Your ref: 3/2016/0022

**Planning Application 3/2016/0022: Proposed demolition of external toilet block and the construction of a single storey extension at the rear of 1 and 2 Abbeycroft; 1 and 2 Abbeycroft, The Sands, Whalley BB7 9TN**

Peter Iles, Specialist Advisory Services

drawing title:  
 EXISTING AND PROPOSED DRAWING

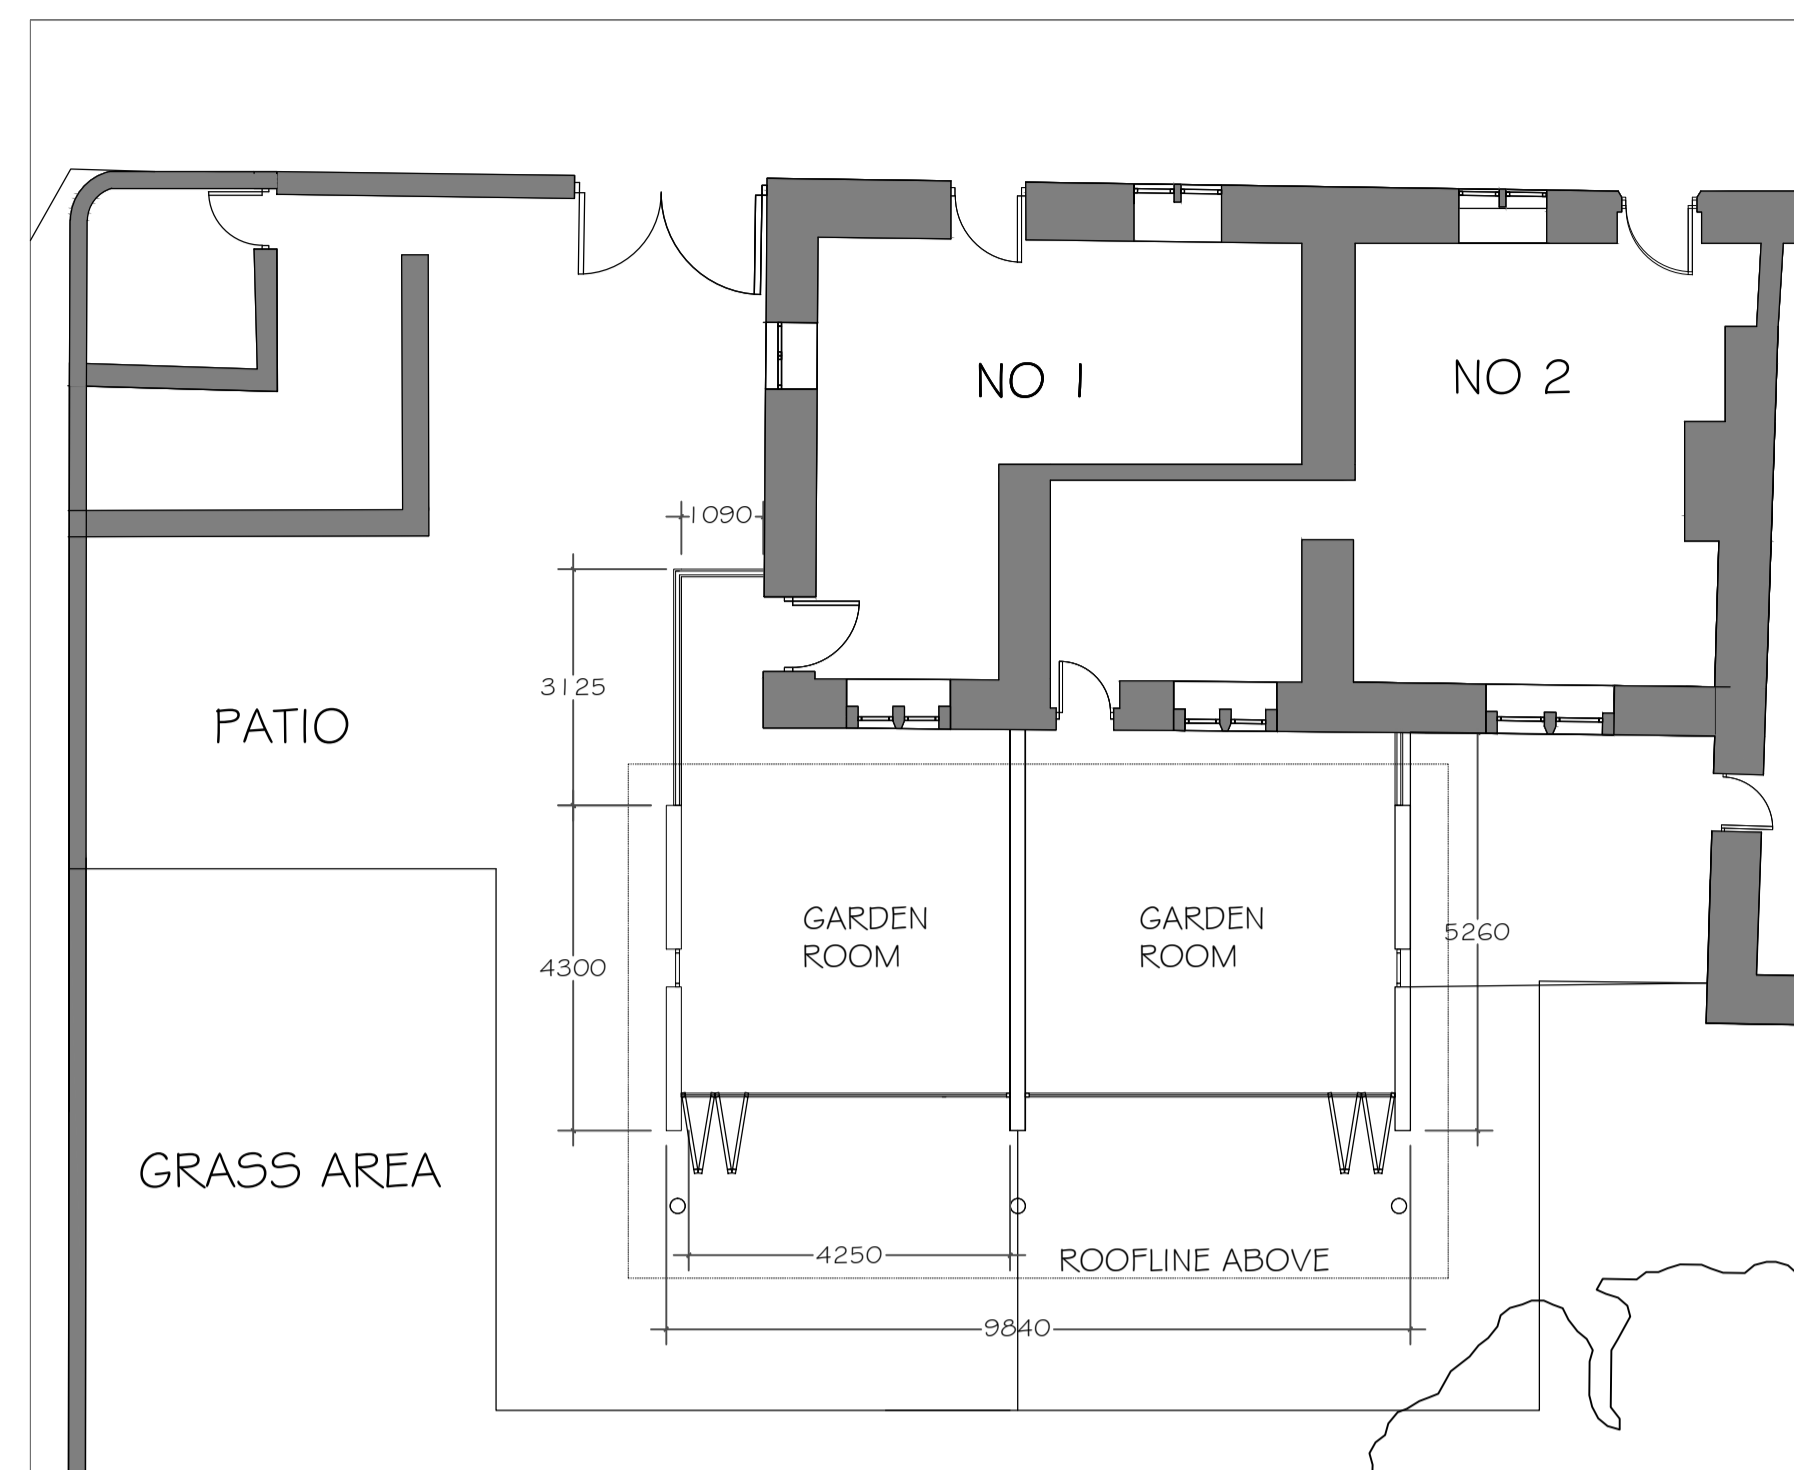
The visual impact on the Listed Abbeycroft will, however, be significant and in our opinion rather incongruous in design. We understand the desire to create something that is modern in both appearance and performance, and that it is not attempting to create a 'pastiche' of historical elements, but consider that the impact is too large to be acceptable. It is felt that the proposed glass wall and doors to the western elevation is unlikely to reveal much of the structure of the original building once the rooms behind

are furnished, and will introduce a new and substantial reflective element onto this historic building. The proposed use of lead as a roofing material is appreciated as a nod to traditional roofing techniques, but such a large expanse of it at a low level like this is unusual and potentially dominating and perhaps even an invitation to crime.
